**ADC Planning Consultation
Response from the Historic Buildings Adviser**

Application Number	FG/6/12 & FG/4/12/L
Address	The Old Barn, Ferring
Description	COU of barn, annexe to A1 and 2 3 bed dwellings. Removal and conversion of warehouses, fenestration etc
Case Officer	Anita Gardner
Site Visit	15 February 2012

Objection

Proposed Landscape Scheme - Plan - GA

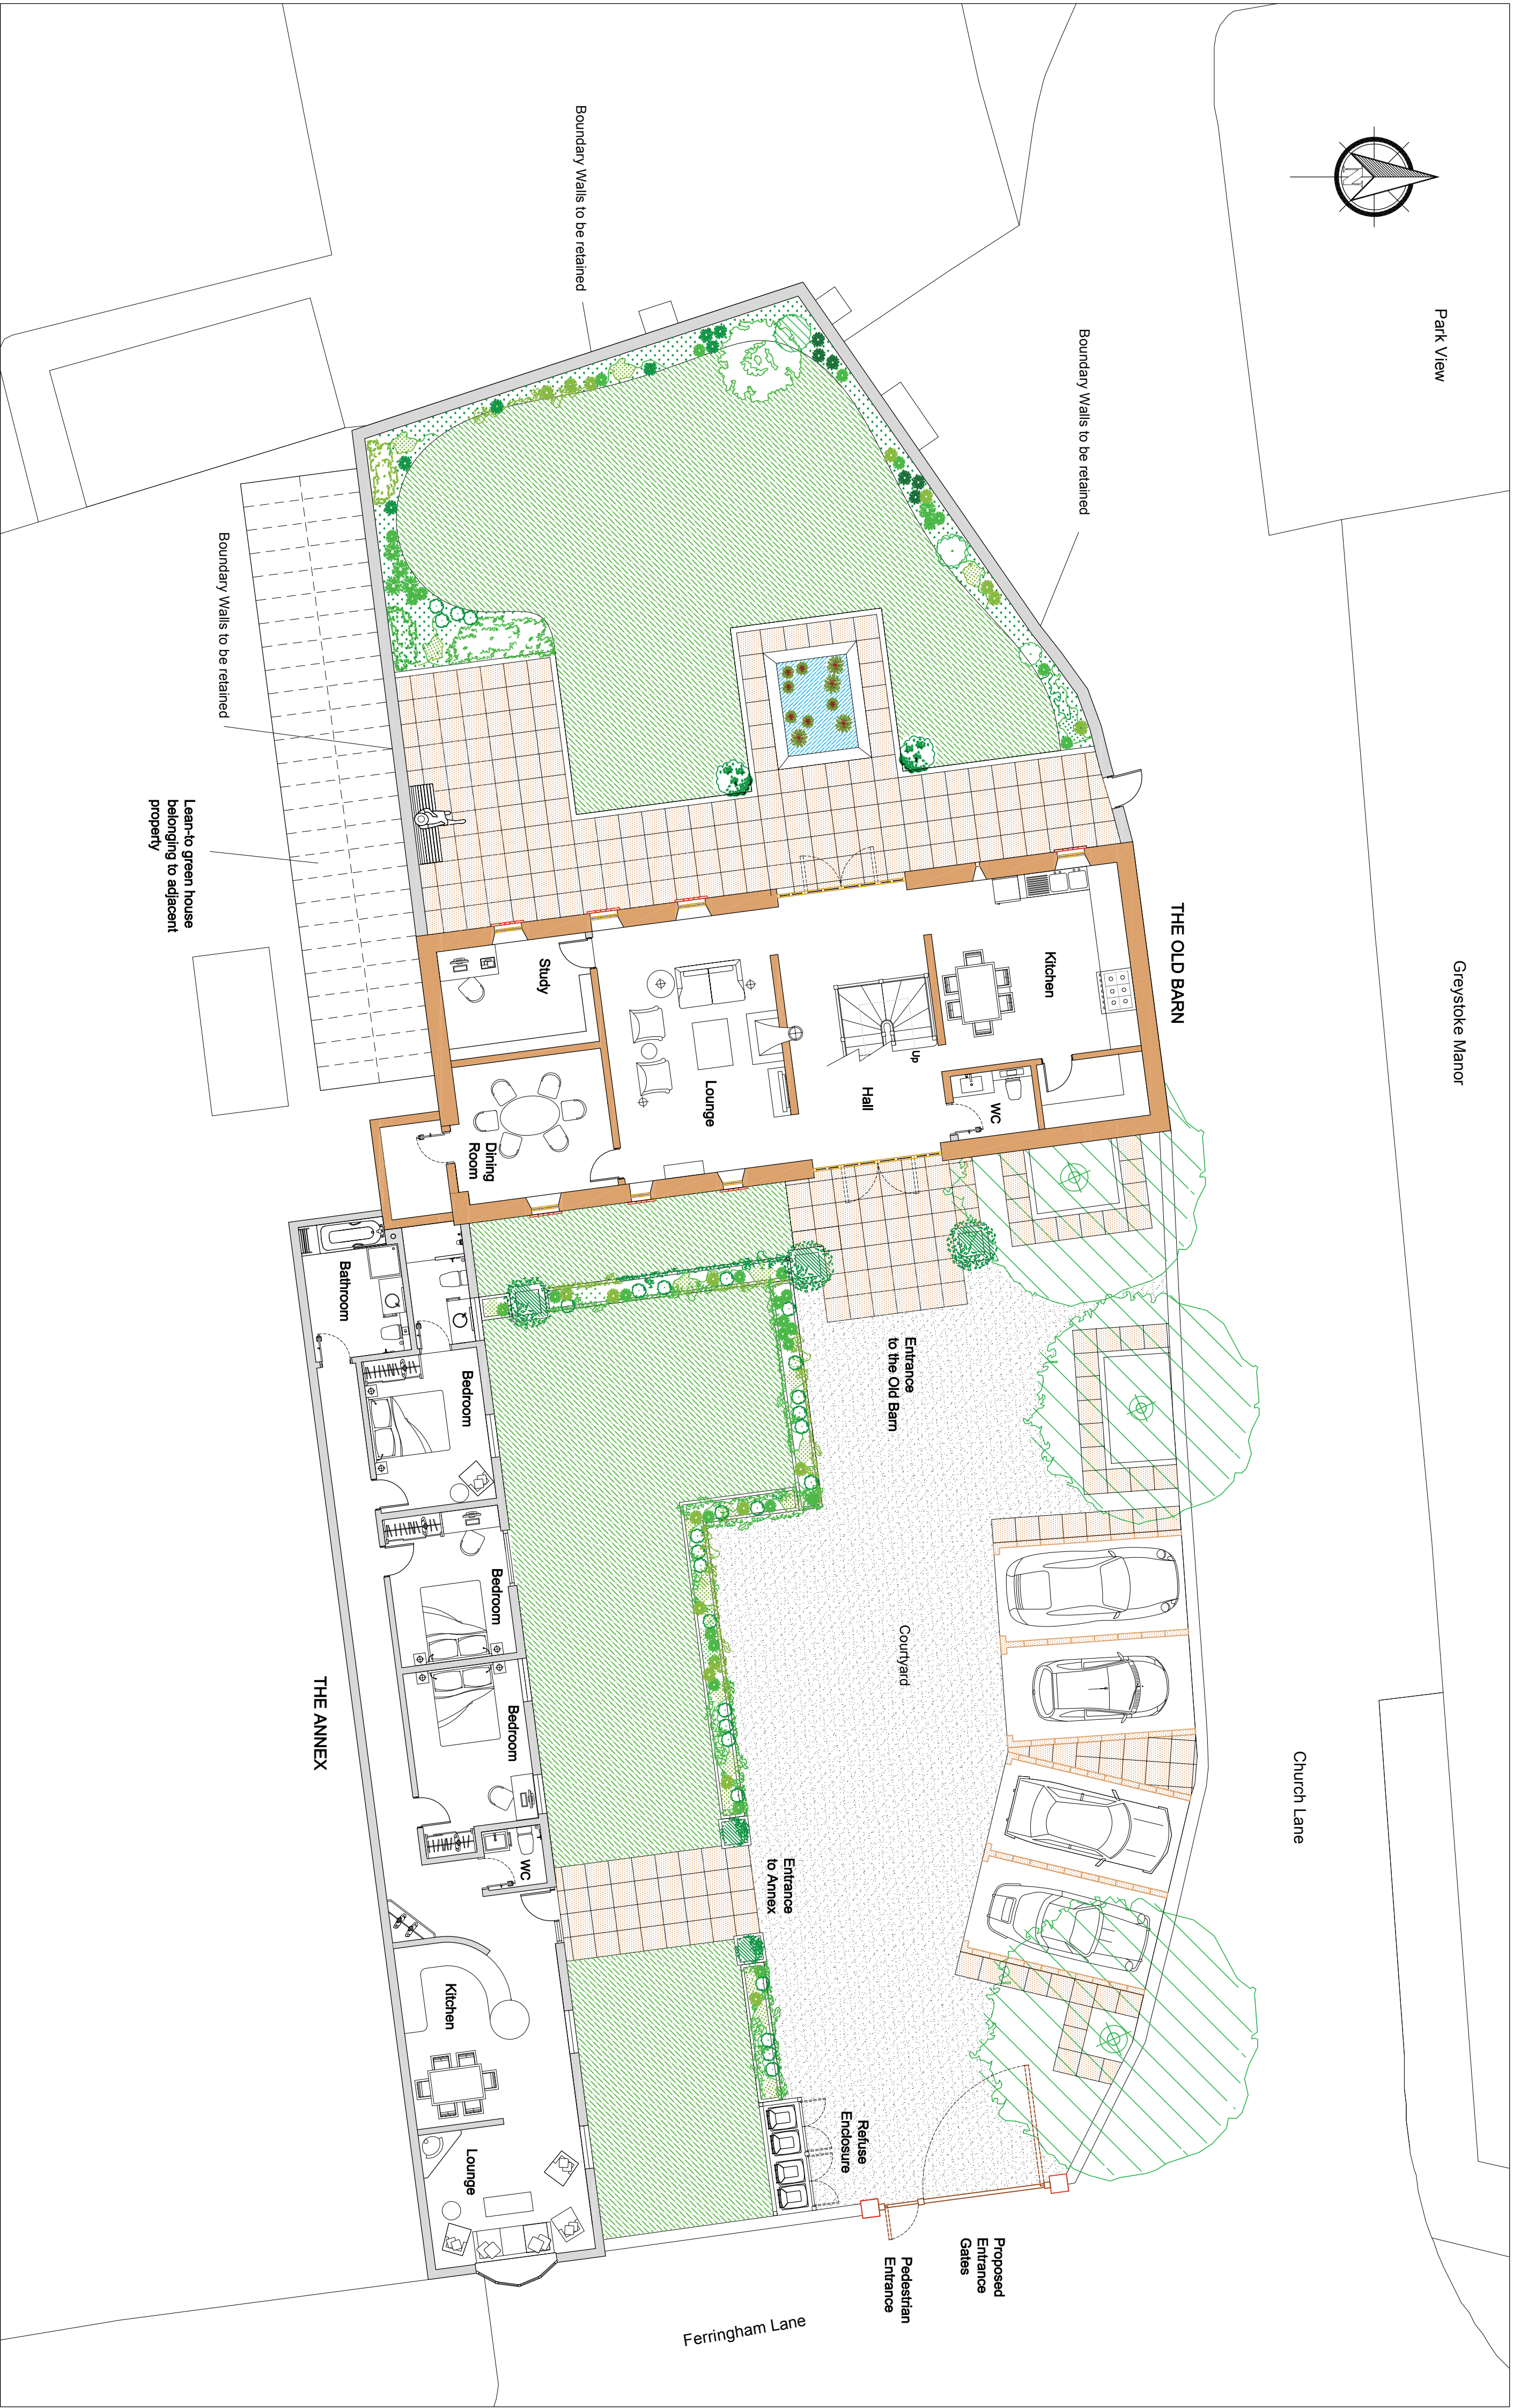
Another main issue with the scheme is the treatment of the courtyard. Given that this forms a major part of the setting of the listed building and is highly visible from the road and the conservation area, a more sympathetic approach should be considered. The use of slabs to delineate parking bays, frame trees and form wide paths is overly complex and formal and too urban in nature. The landscaping here should be much more subtle and softer in its appearance and seek to enhance the character of the barn rather than suburbanize it. Policy HE 10.2 of PPS5 asks that planning authorities 'should identify opportunities for changes in the setting to enhance or better reveal the significance of a heritage asset'. Such an opportunity exists here.

1 Foxcombe, South Haring, Penrith GU27 9PL
t: 01733 12 88 88
email: hobbesj@febdesign.com
Bolrush Developments - The Old Barn - Fering
The Annex - Proposed Elevations

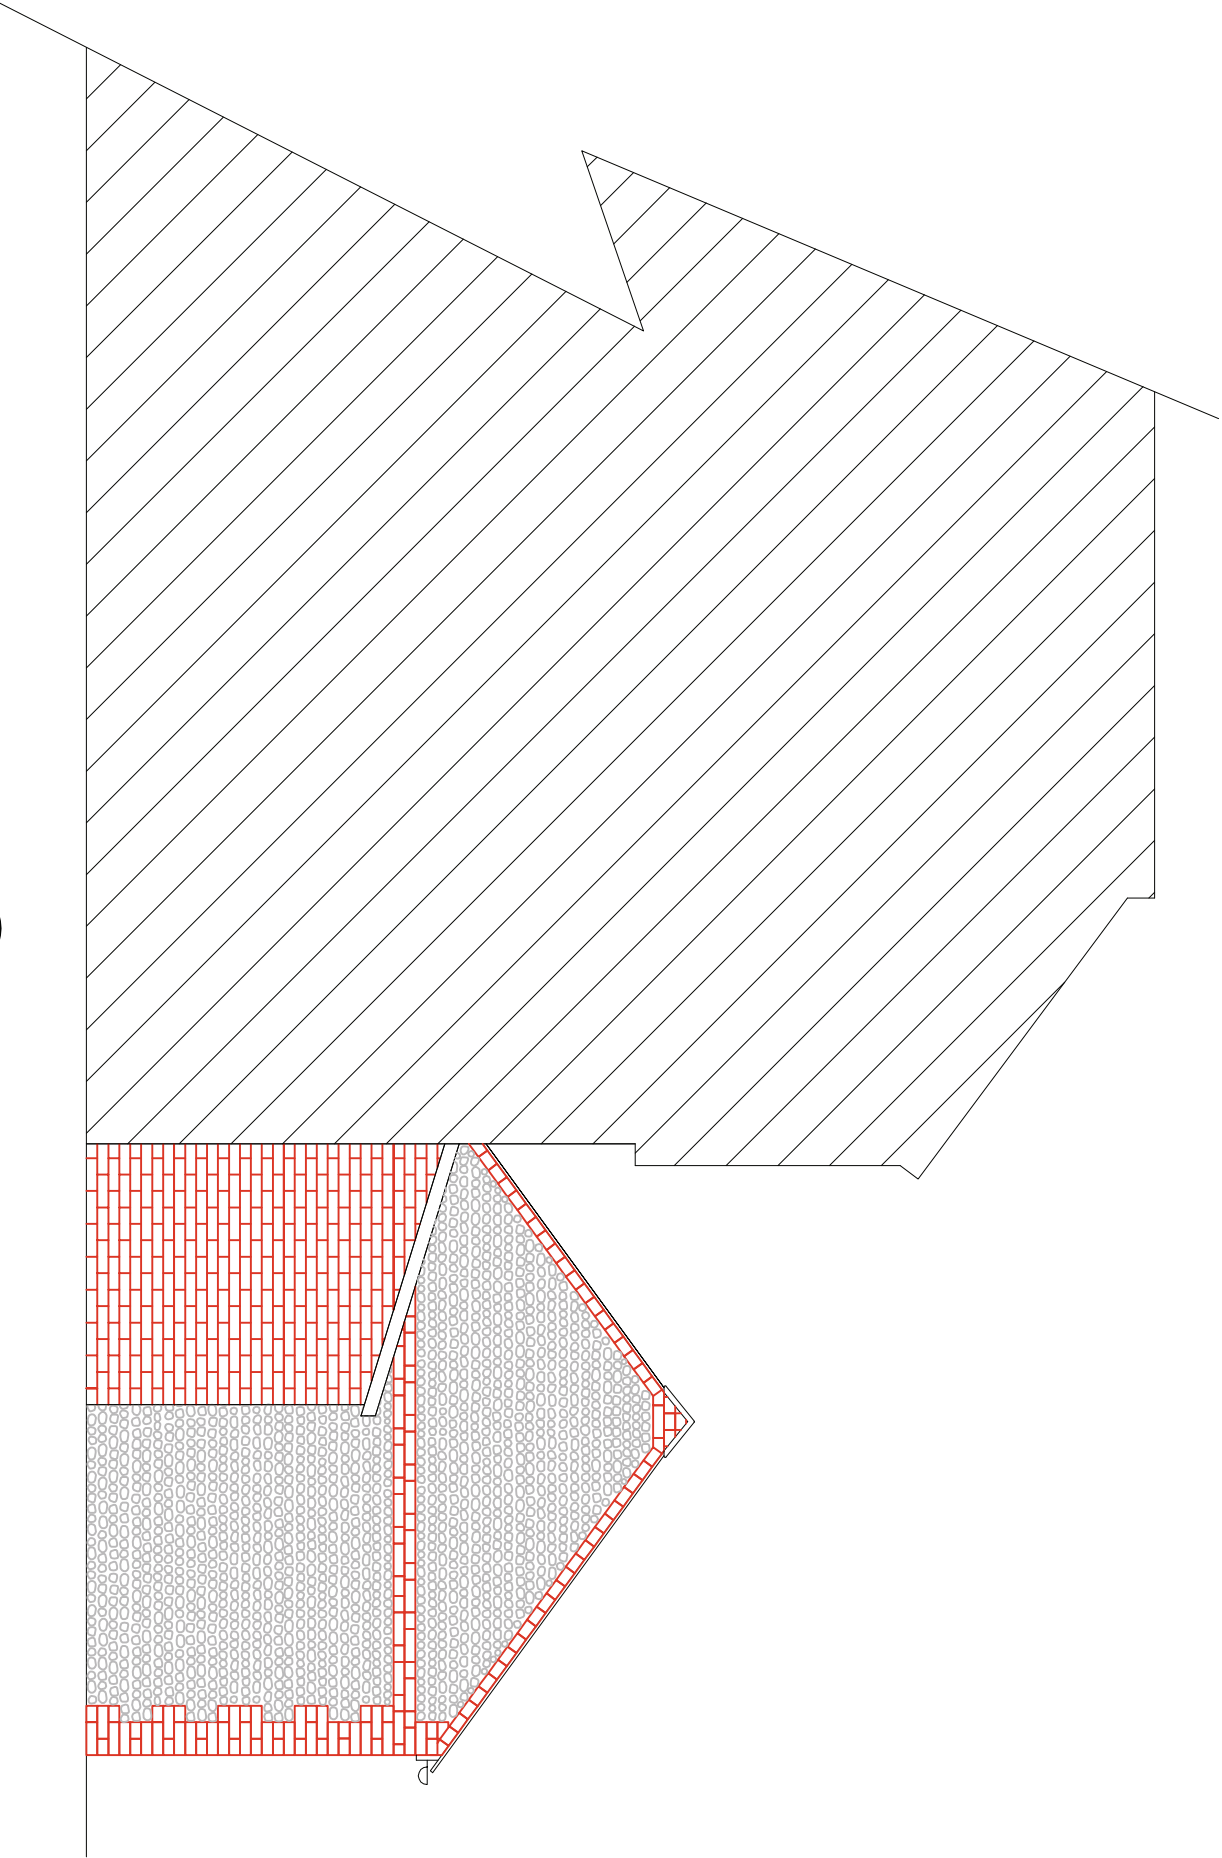
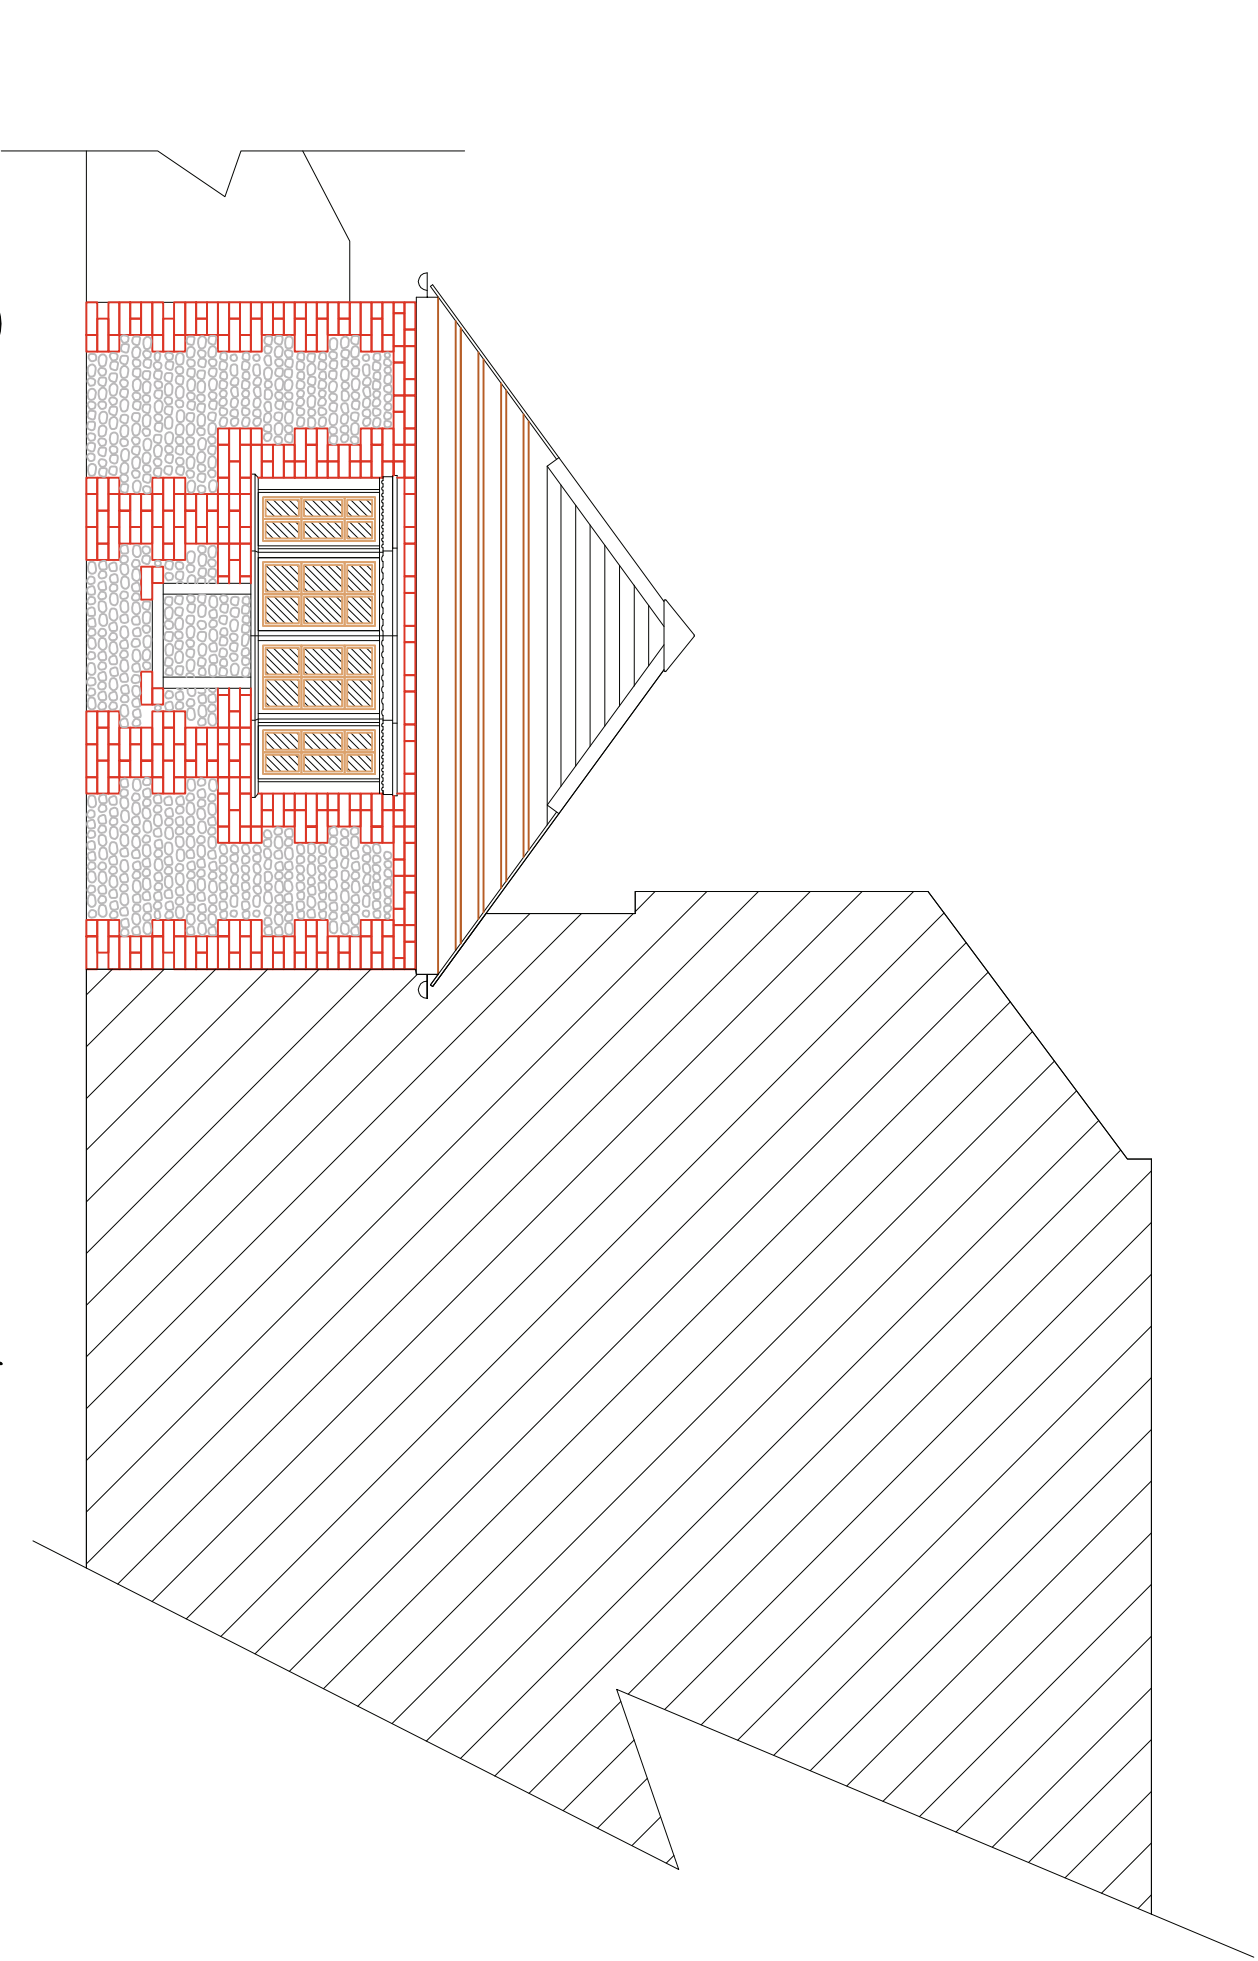
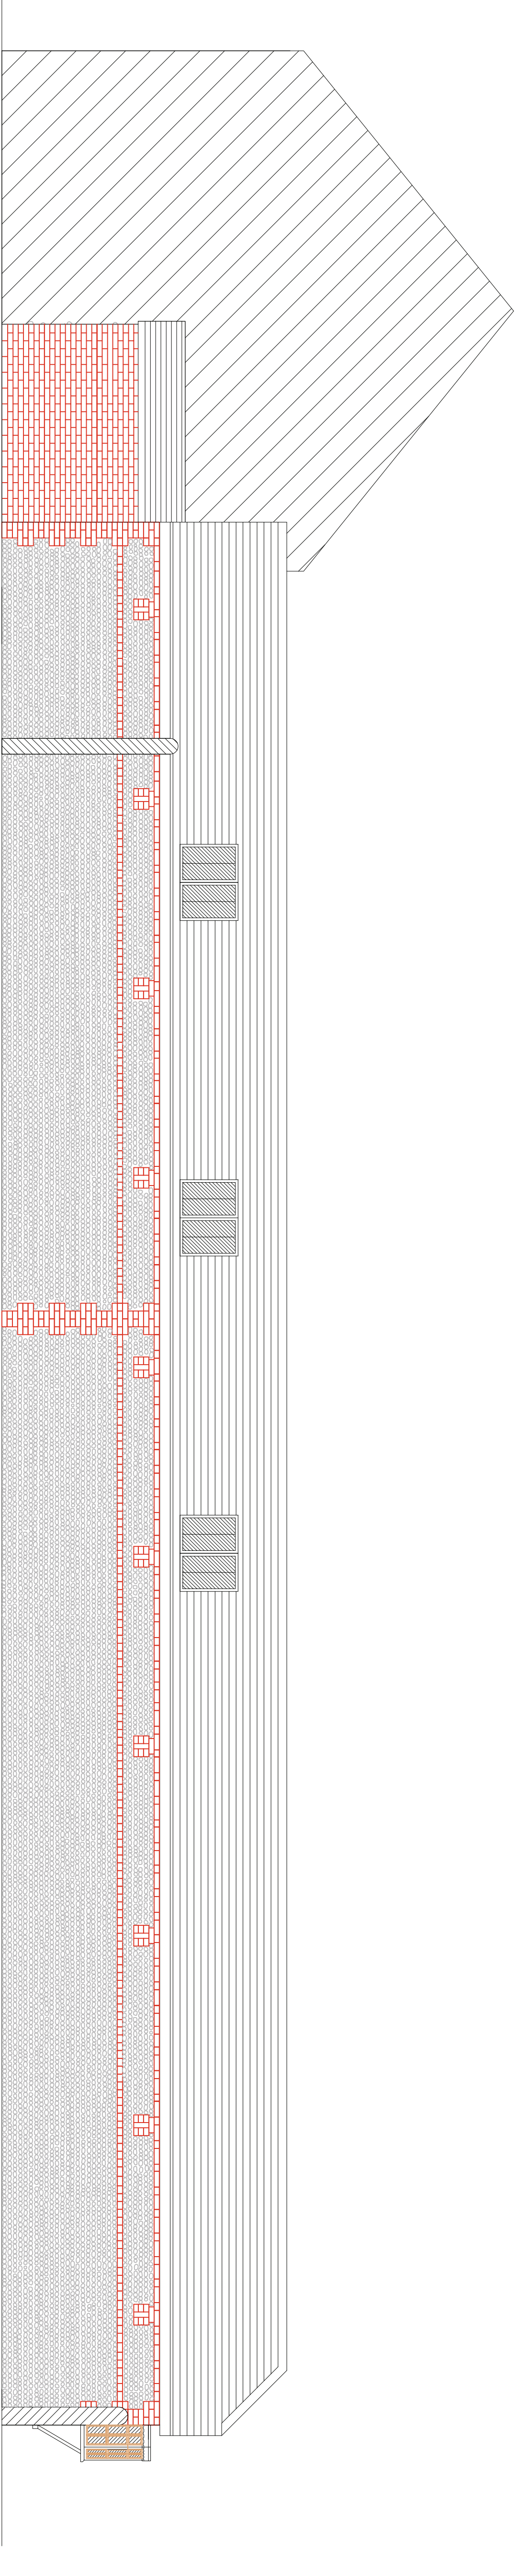
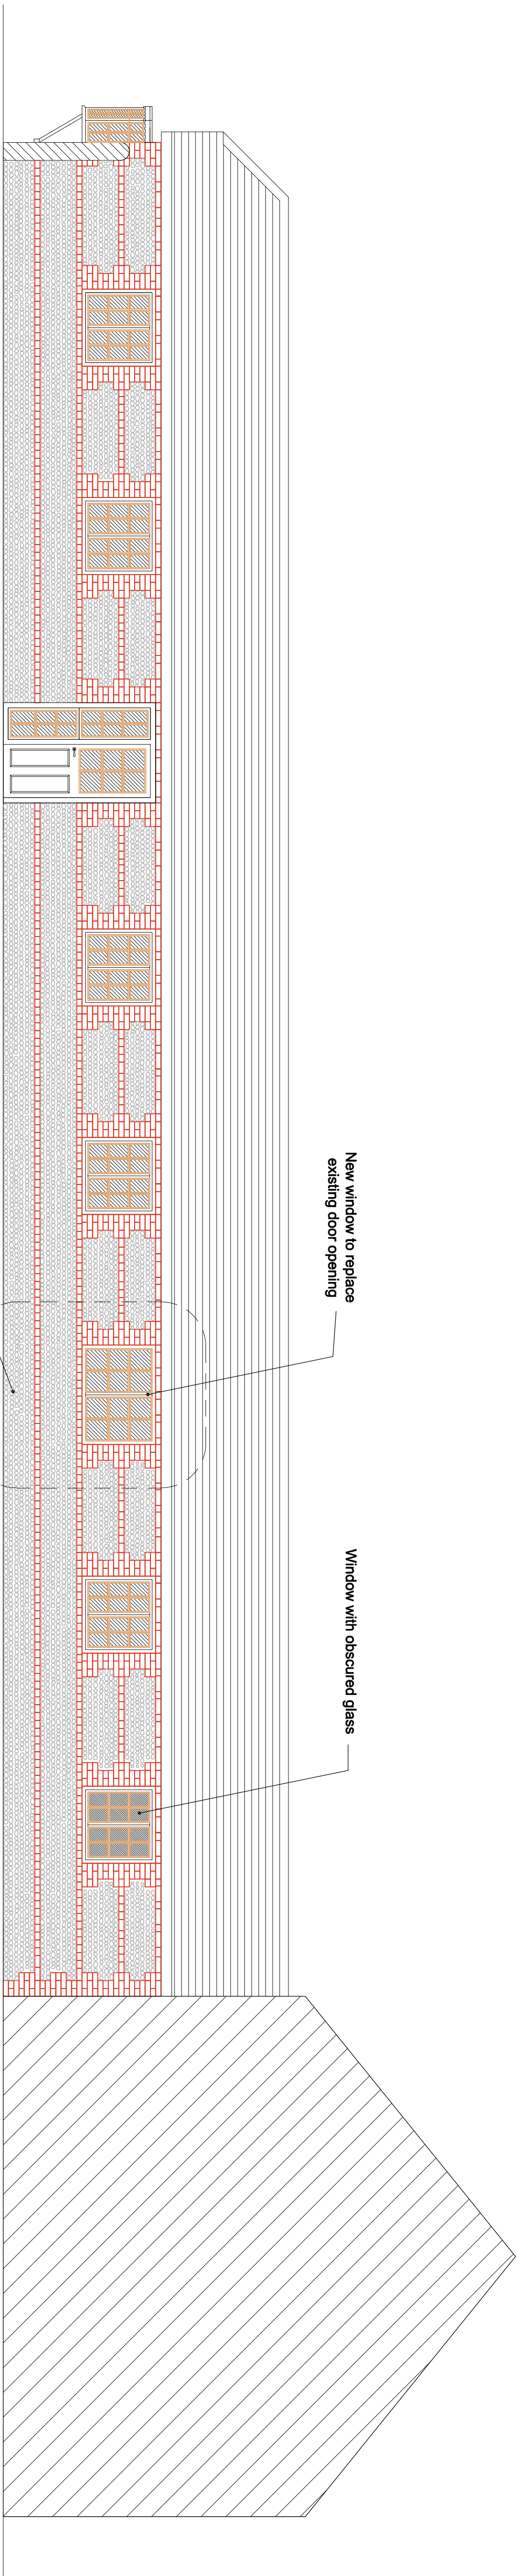
The conversion of the annex is more successful and results in little alteration to the exterior. That said, the window design might benefit from referencing the existing and the bay window to the east would be better removed. This is not sympathetic with the building.
